Re: Exploratory Works for Snowy 2.0 – Second amendment to Talbingo boat ramp

This letter provides details on a second amendment to the design of the Talbingo boat ramp upgrade which forms part of the proposed Exploratory Works for Snowy 2.0. This letter replaces the letter provided to the Department on 25 October 2018 which provided details on the first amendment to the design of the Talbingo boat ramp.

### Amended plans – Talbingo boat ramp upgrade

Figure 2-22b: Talbingo Recreational Area (Option 2B)

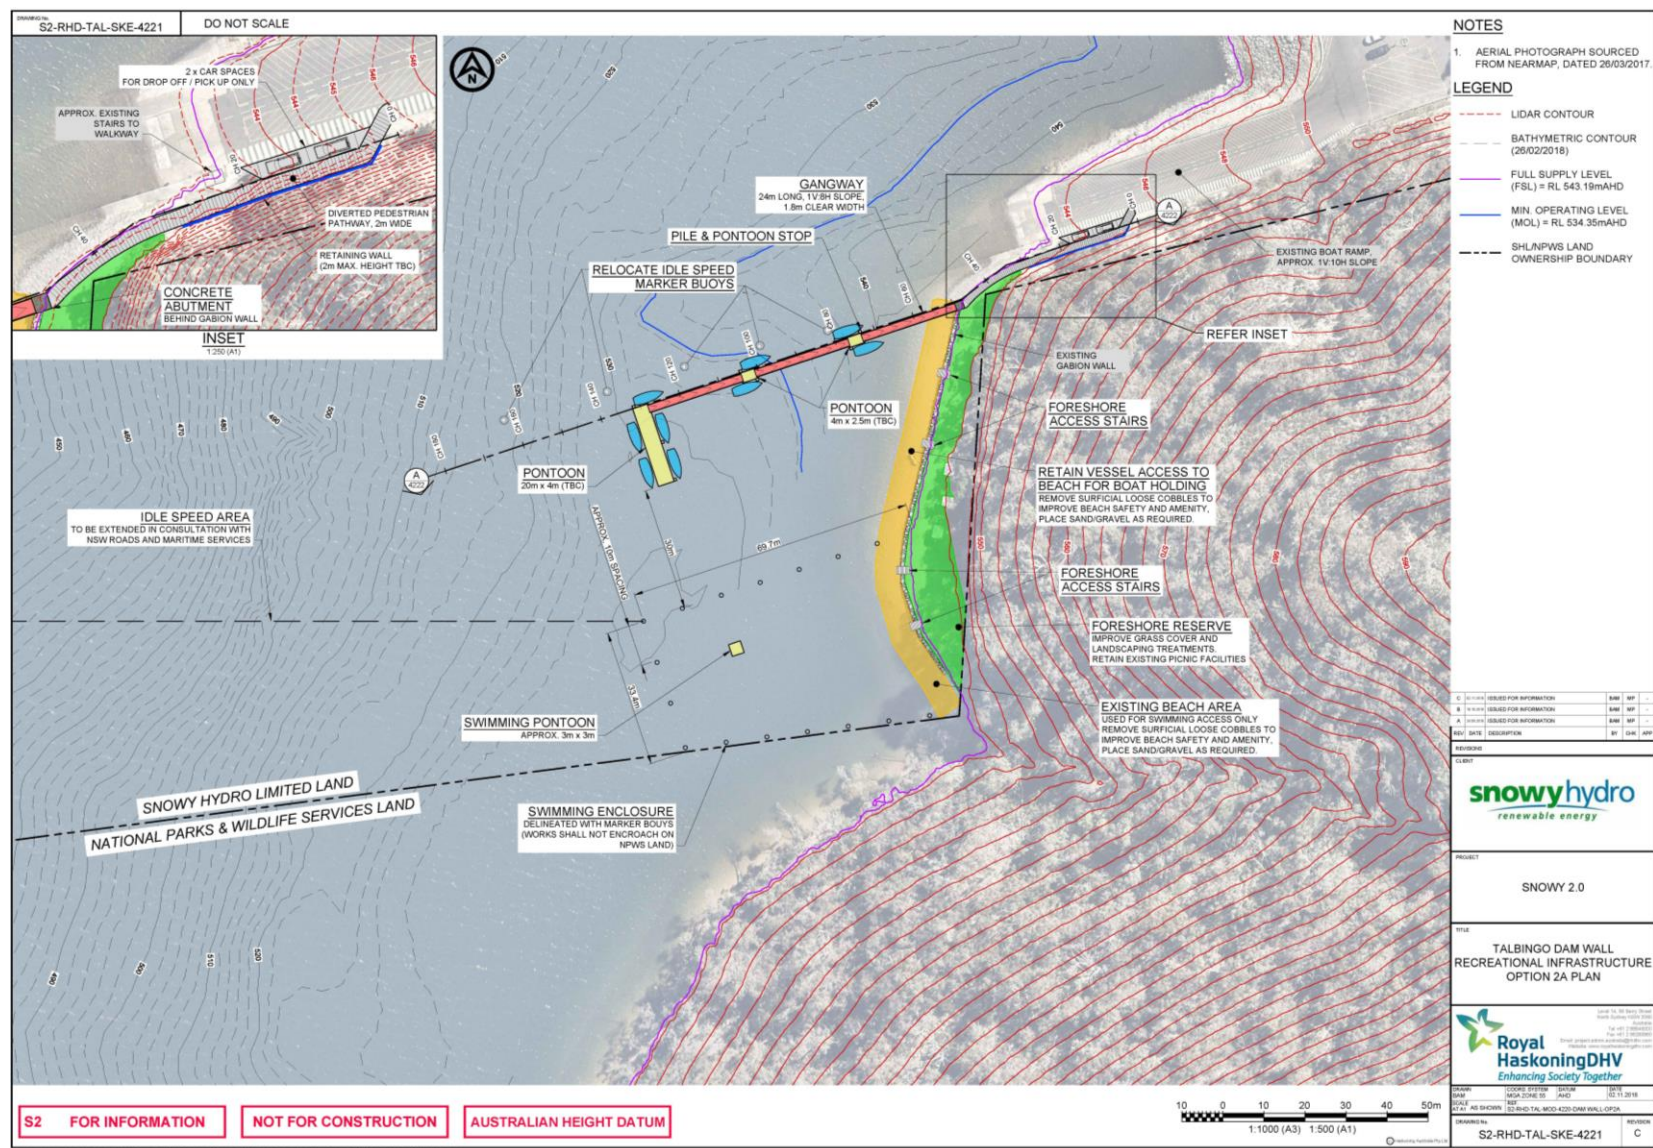
Following consultation with members of the Talbingo community and the Department after 25 October 2018, the plans of the upgrade to the Talbingo boat ramp have been further amended to include two parallel parking spaces near the boat ramp for people with All Abilities. To allow for these two parking spaces, the existing pedestrian pathway on the southern side of the boat ramp will be diverted further to the south. A minor amount of excavation within the existing batter slope to the south of the boat ramp will be required for the construction of the diverted pedestrian pathway resulting in a retaining wall up to about 2 metres high.

Current plans of the upgrade to the Talbingo boat ramp (incorporating the two parallel parking spaces for people with All Abilities) are provided in Appendix A. These plans are consistent with the three options presented in the RTS apart from works or structures on NPWS owned land and the provision of the All Abilities parking spaces. The plans provided in Appendix A are intended to replace the indicative layouts presented in Figure 3.1, 3.2 and 3.3 of the RTS.
